MECKLENBURG COUNTY  
Park and Recreation Department

MEMORANDUM

**DATE:** December 20, 2023

**RE:** Rezoning Petition #2023-162  
PID# 18312111

**RZ-100**

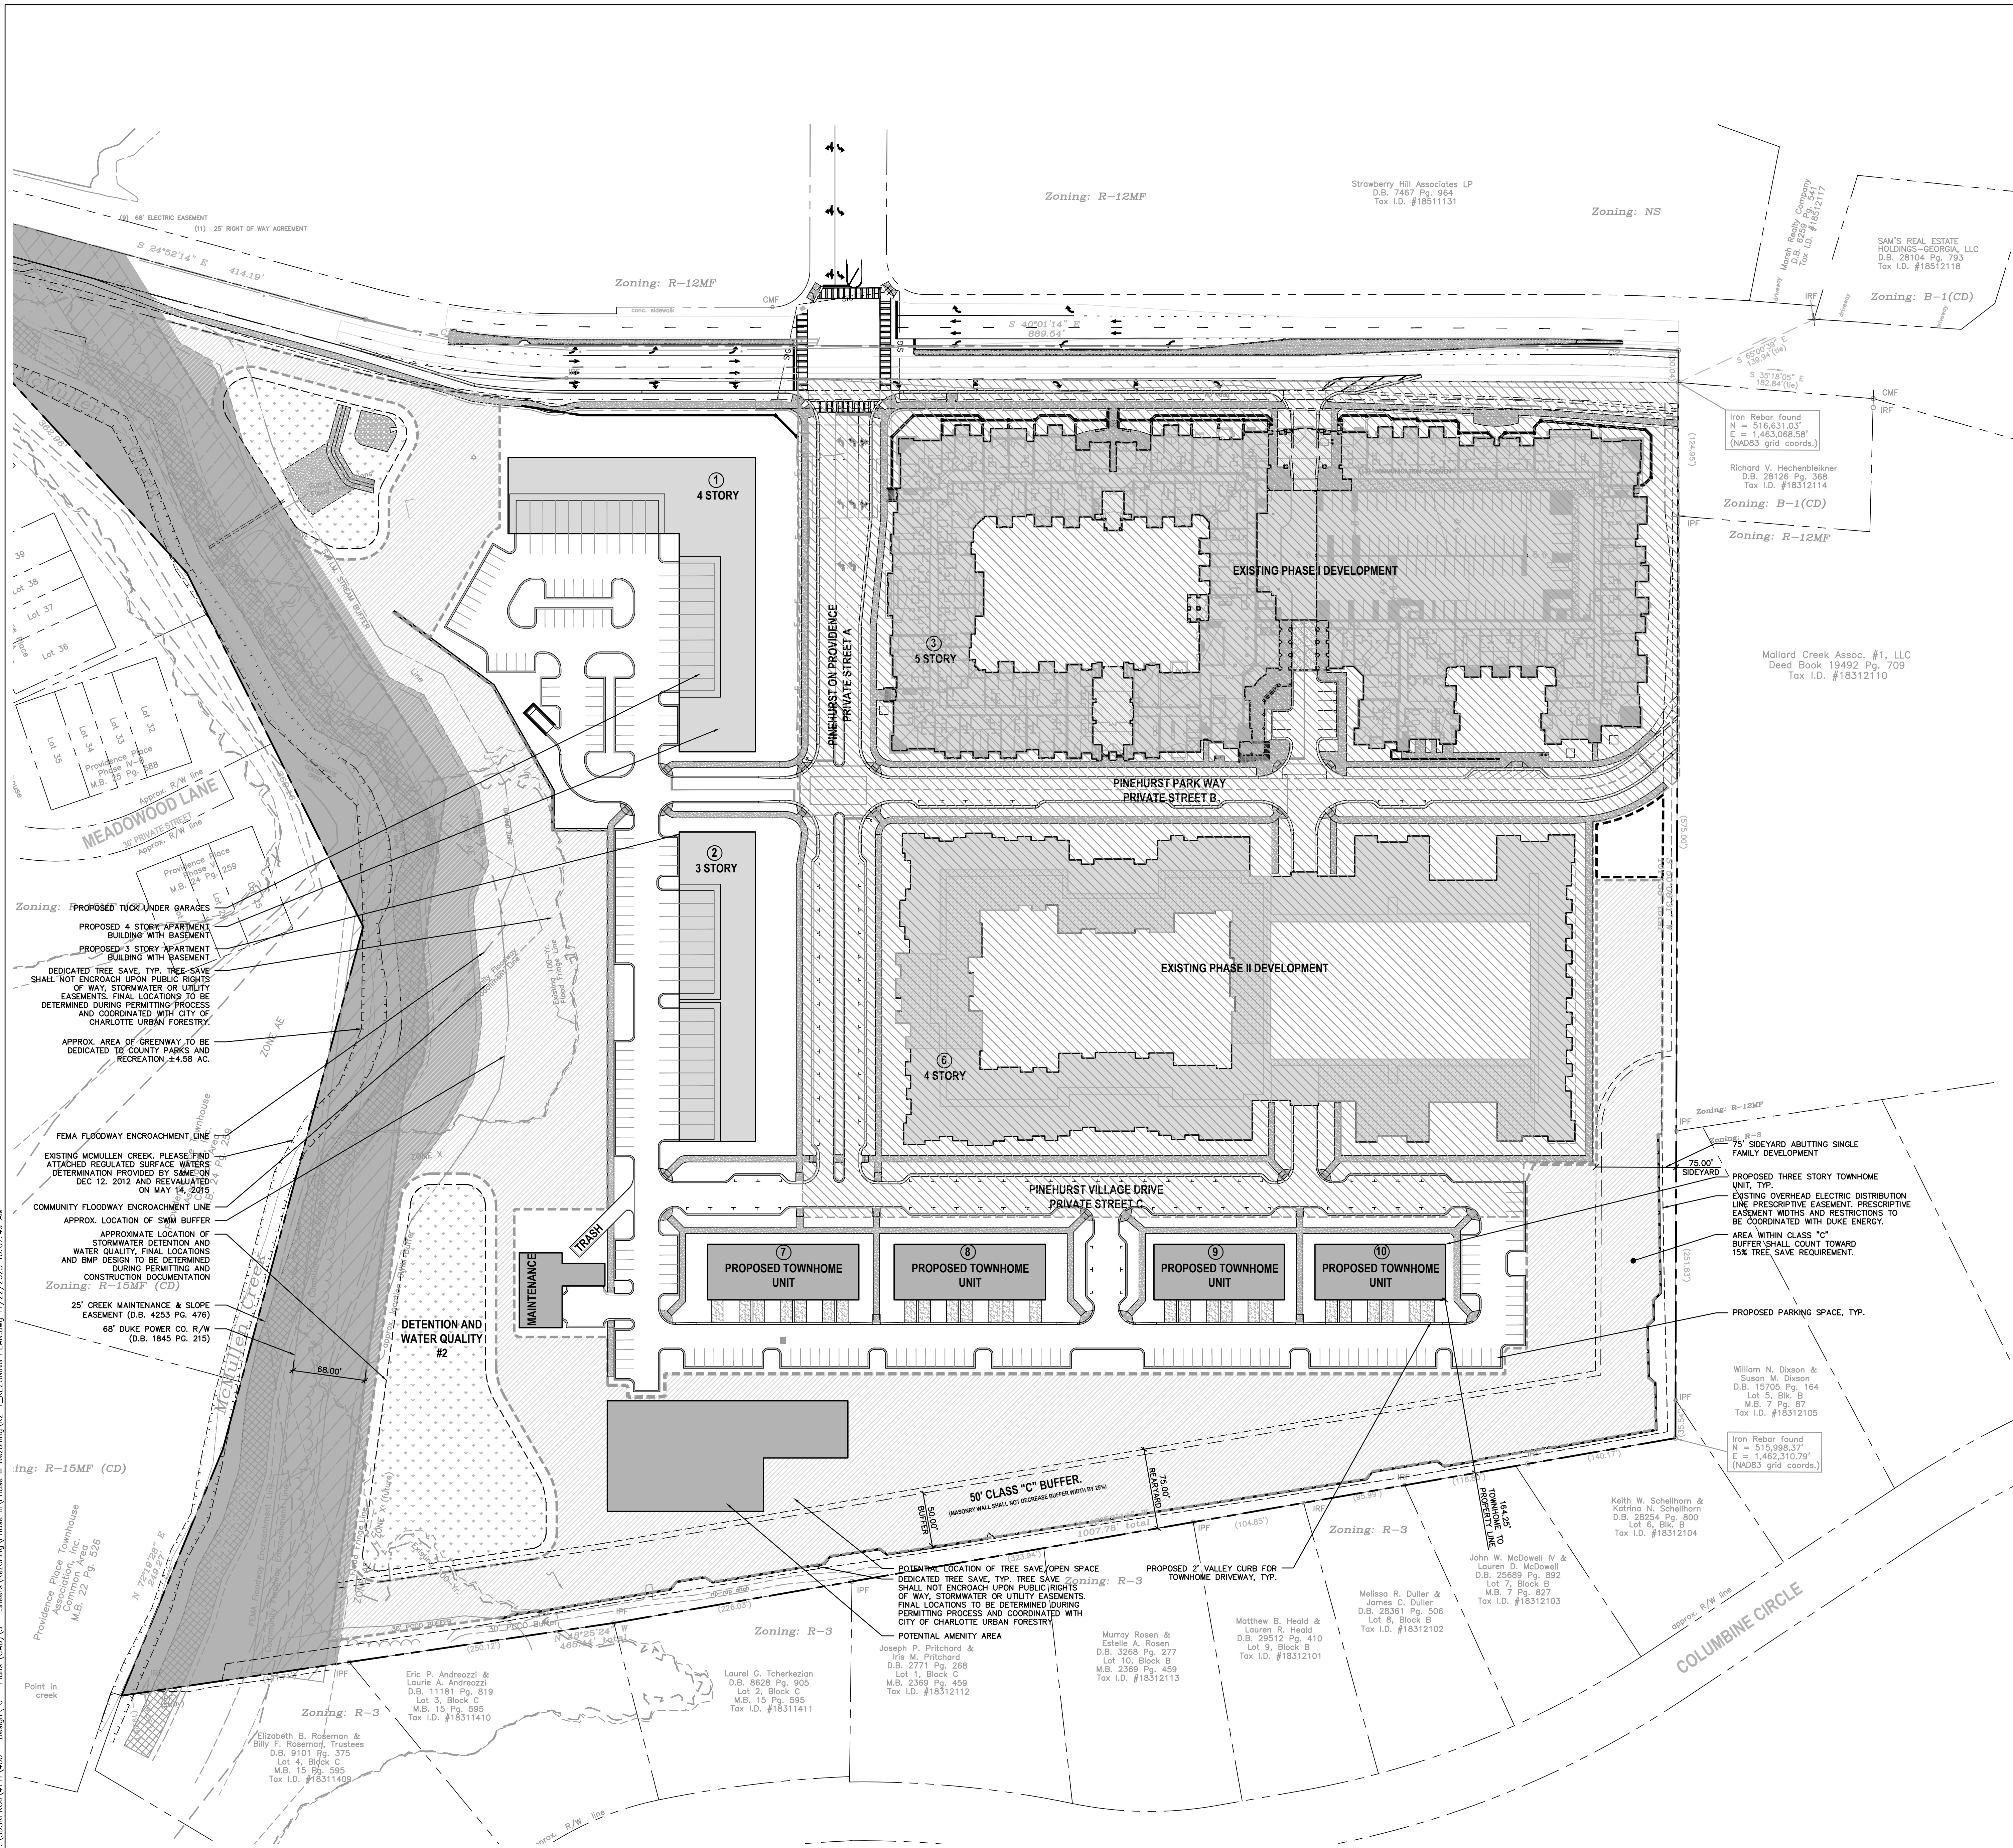
MCPR requests to revise the greenway dedication note to say: "Dedicate and convey to Mecklenburg County". MCPR also requests the dedication and conveyance of a minimum of 100' wide easement between the greenway dedication area and the public ROW for a future accessible bike/ped trail connection to the development. Greenway dedication shall be conveyed by the first CO.
